J.S. THOMPSON ENGINEERING, INC

September 25, 2023

The plan was reviewed for the 30'-0" x 40'-0" barn at 189 Spence Road in Lillington, North Carolina to address the necessary construction requirements. Analysis revealed the following:

David Allgood
189 Spence Road BARN
Lillington, NC

WALL BRACING NOTES AND DETAILS

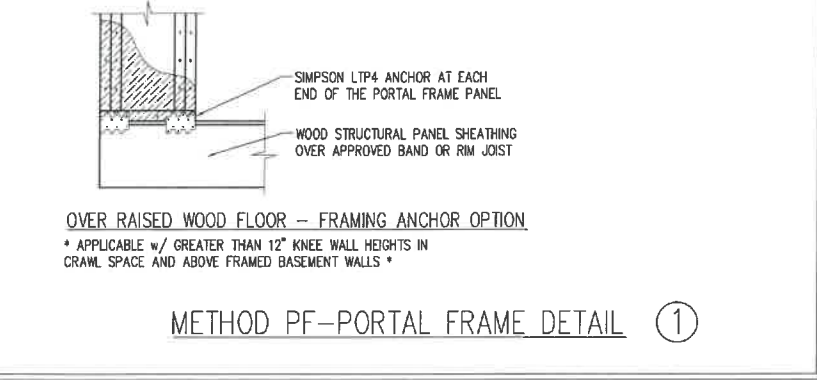
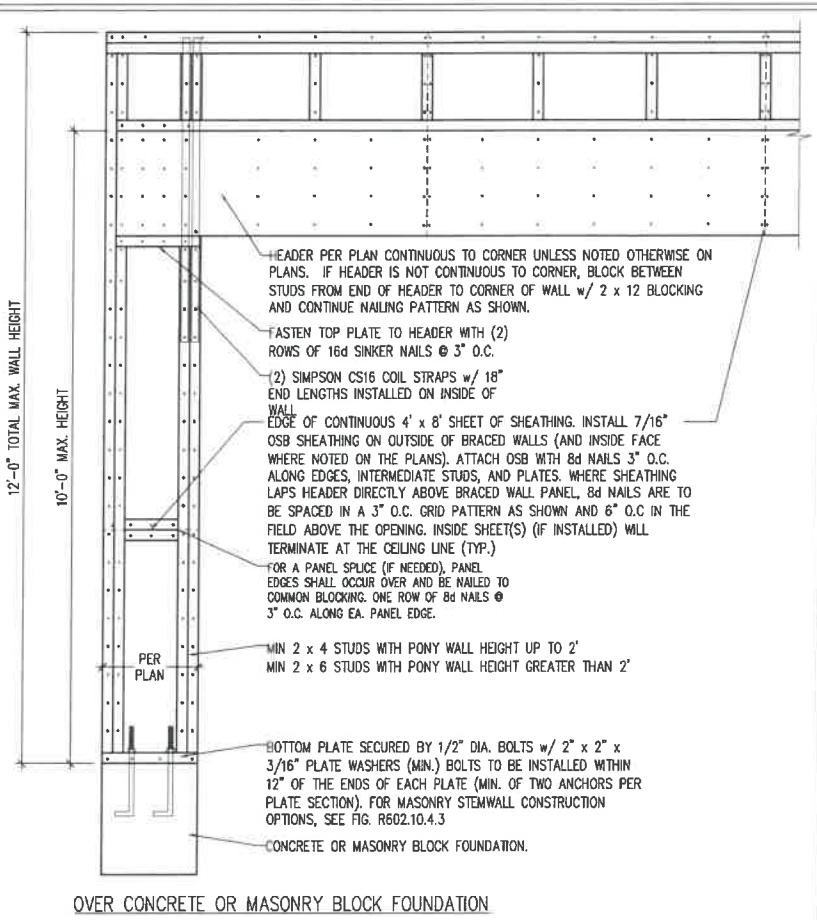
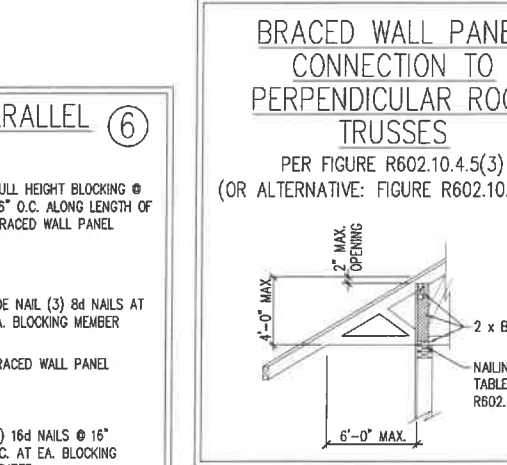
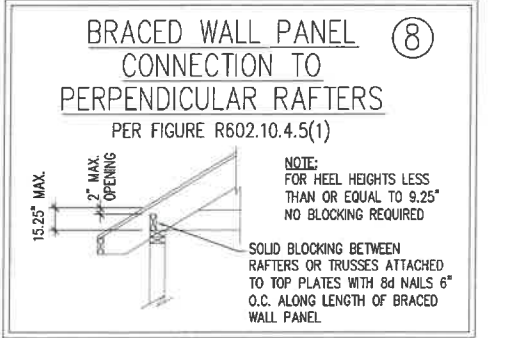
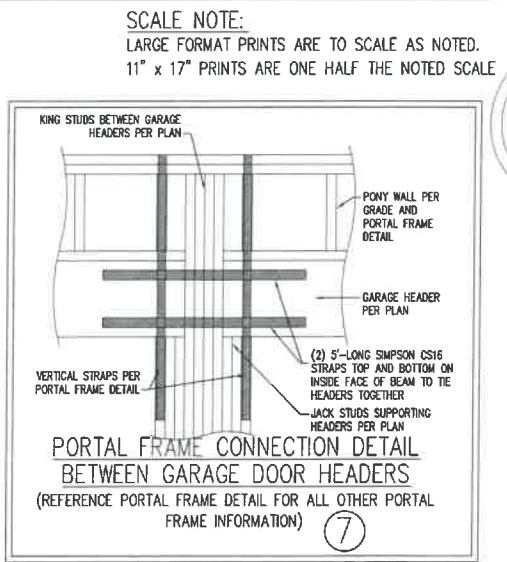
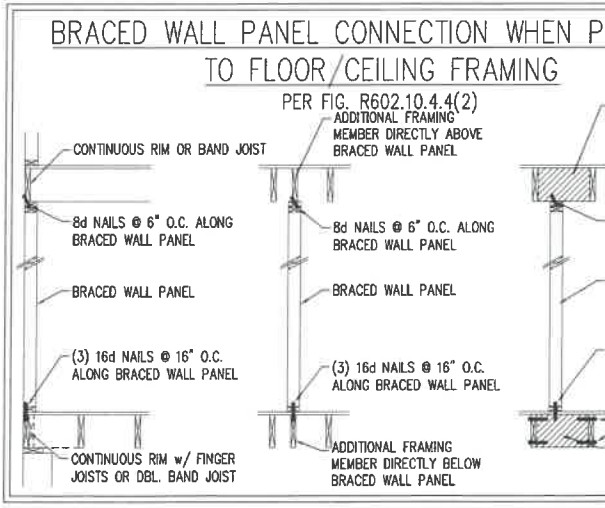
- 2) Walls framed to 12'-0" height on the foundation require 2 x 6 @ 16" o.c. SPF #2
- 3) The 9/0 x 8/0 garage door at the gable end requires (3) 2 x 12 SPF #2 or SYP #2 header with (2) jacks and (4) king studs at each end. Stud columns are to be fastened with Simpson CS16 strapping at 24" o.c. The opening is to be framed using CS-PF portal requirements. See attached wall braced design notes and detail sheets.
